From: Sue Howell
Sent: 14 June 2018 16:43
To: Planning.Responses
Cc: Simon Davis
Subject: RE: Planning Consultation on: AL/40/18/PL

Comment from Greenspace

NOTIFICATION FROM ARUN DISTRICT COUNCIL
Town & Country Planning Act 1990 (as amended)
Town and Country Planning (Development Management Procedure)
(England) Order 2015
Planning Permission
APPLICATION **AL/40/18/PL**
NO:

Registered: 18th April
 2018
Site Address: Land Adjacent to 14 St Johns Close Westergate
 PO20 3TH
Grid Reference: 93700 04500
Description of Works: 2 No. semi detached bungalows with associated parking & landscape

location plan &
proposed site plan

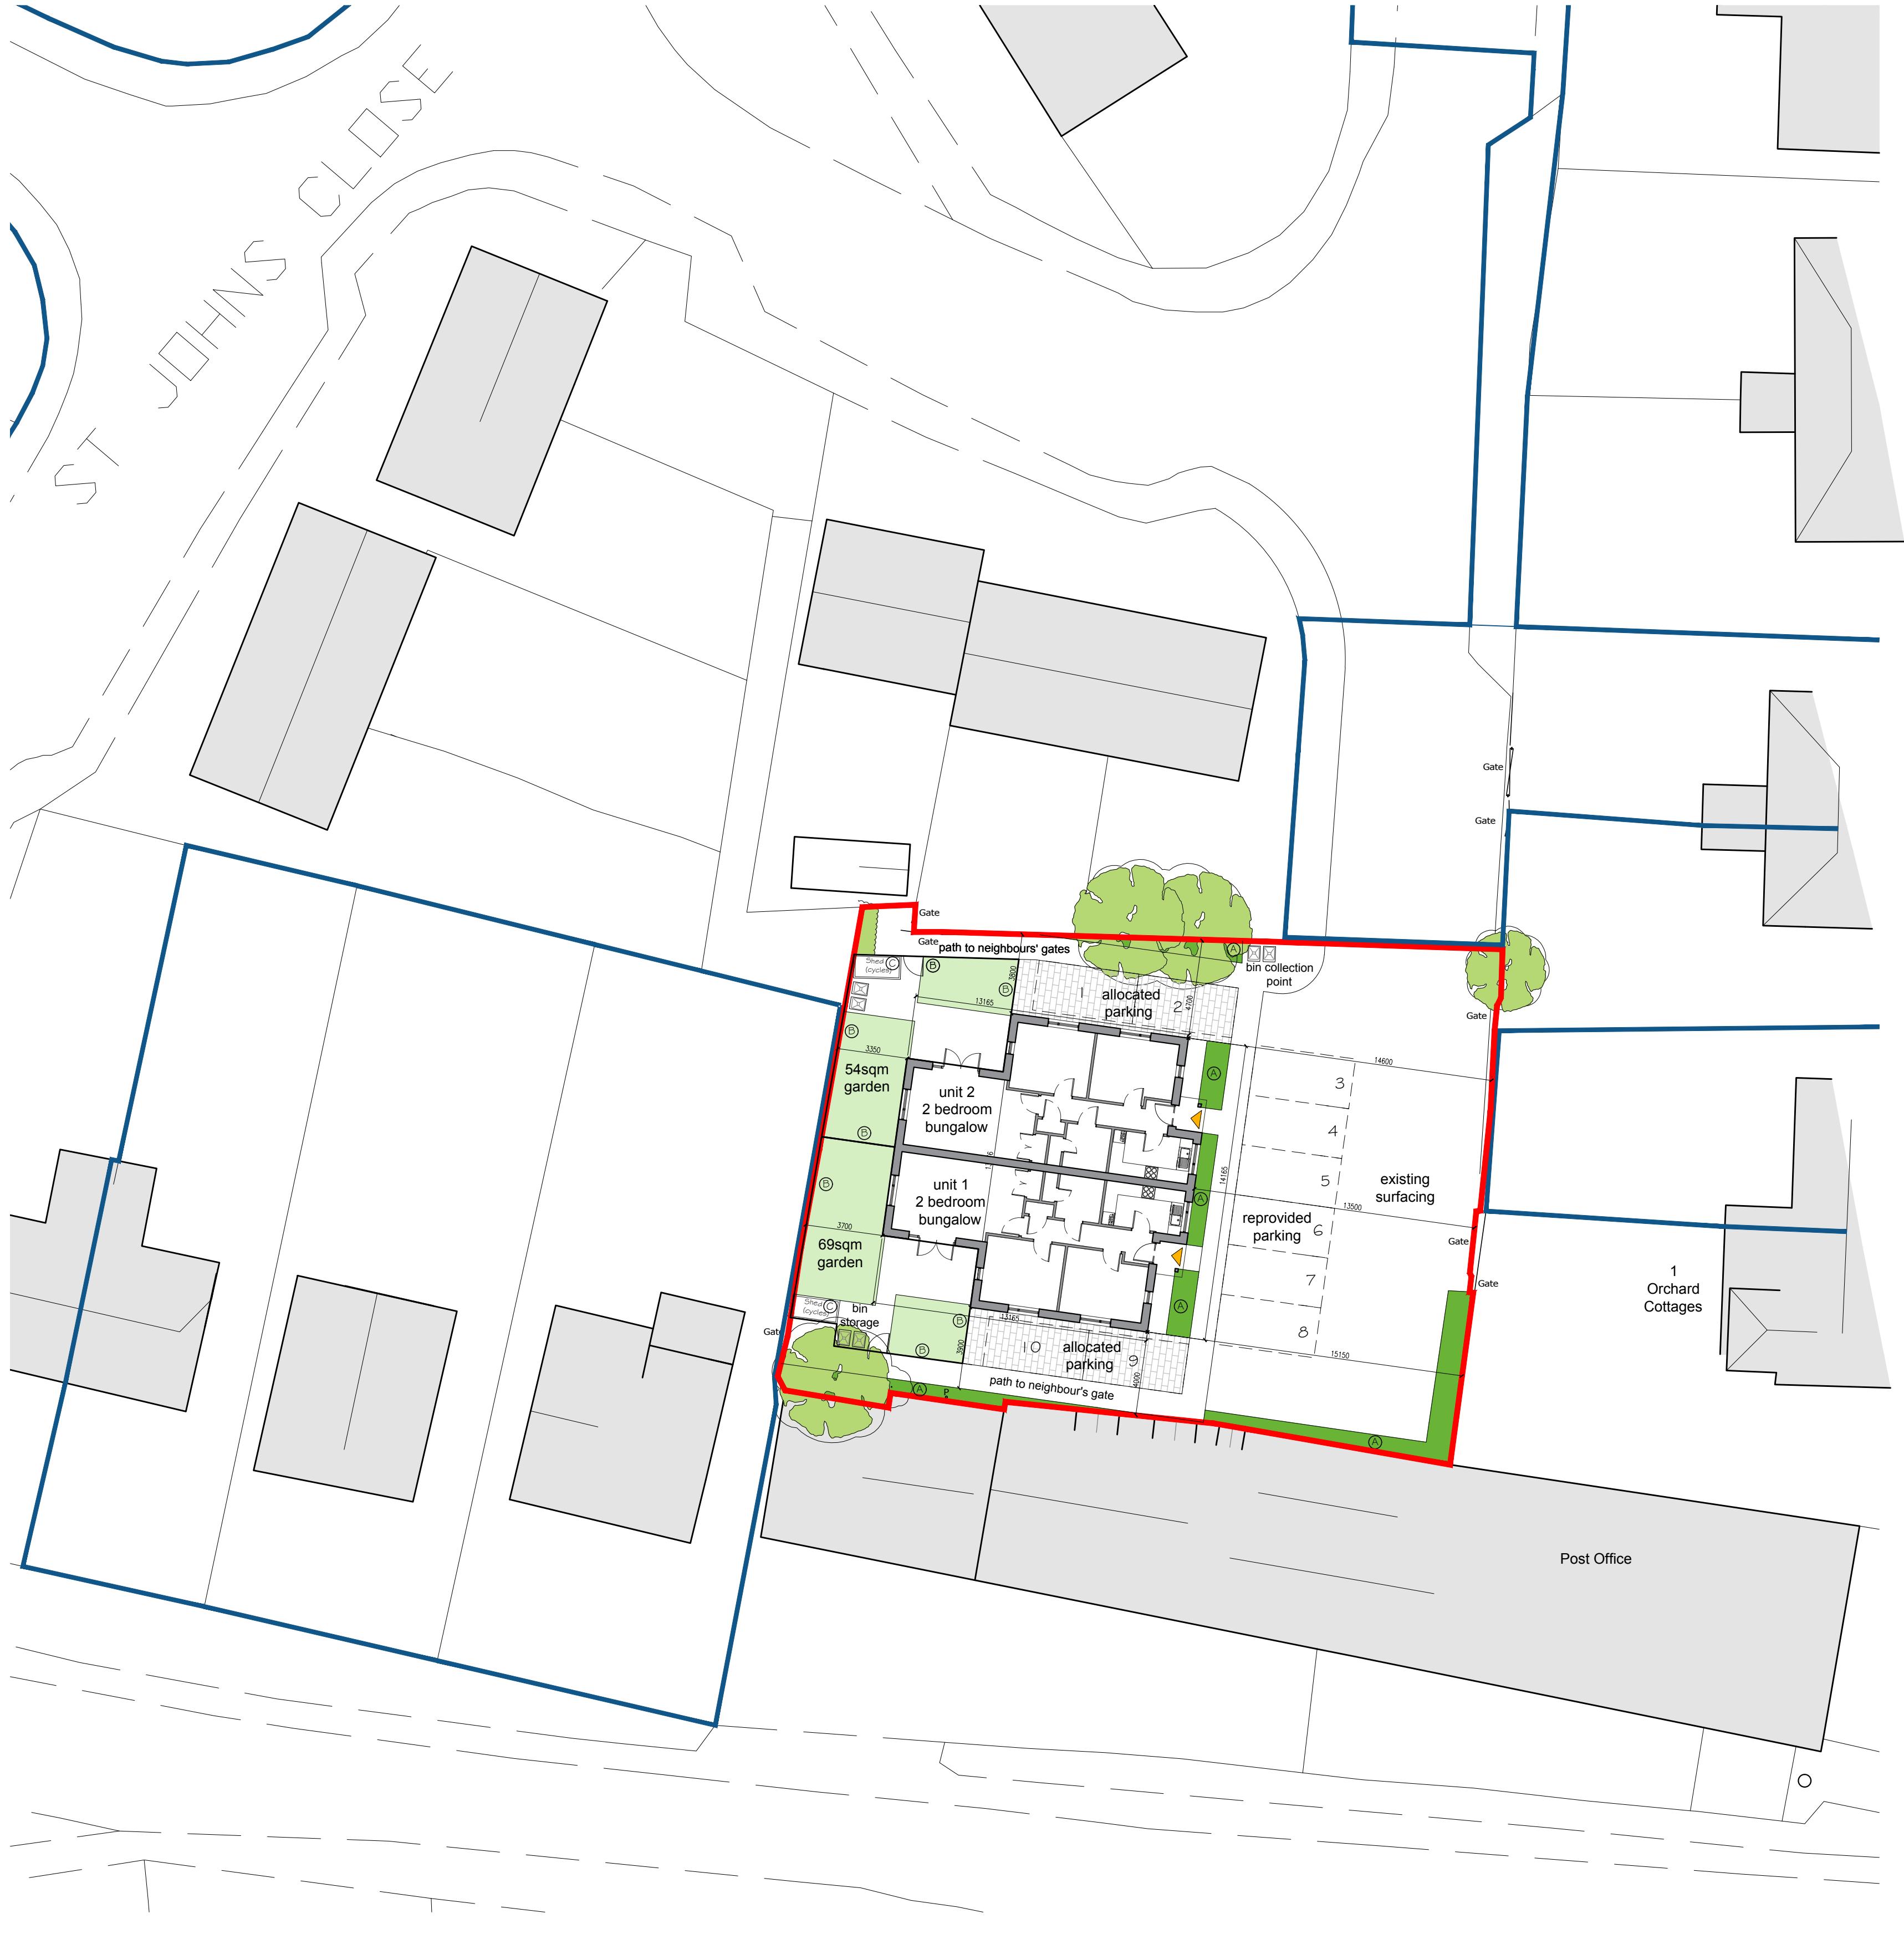
The proposals put forward in this application for the replacement of hardstanding with dwellings will have no perceived detrimental landscape impact. The proposals have indicated some greening to frontage with grass to the rear. With this being a smaller development of less than 7 dwellings then open space on site is not a consideration. However development of any kind should consider greening to add to the proposal and to enhance the setting. Indicative landscaping has been shown, for this development, further landscape detail should be provided forming a scheme that will maximise the biodiversity of the site with the inclusion of mixed ornamental and native species for the creation of a variety of habitats. The landscape proposals will need to be shown in plan form detailing species choice, planting densities and size at time of planting.

Any adjacent trees associated with this location and offsite that may have roots within the development area should be subject to tree protection measures.
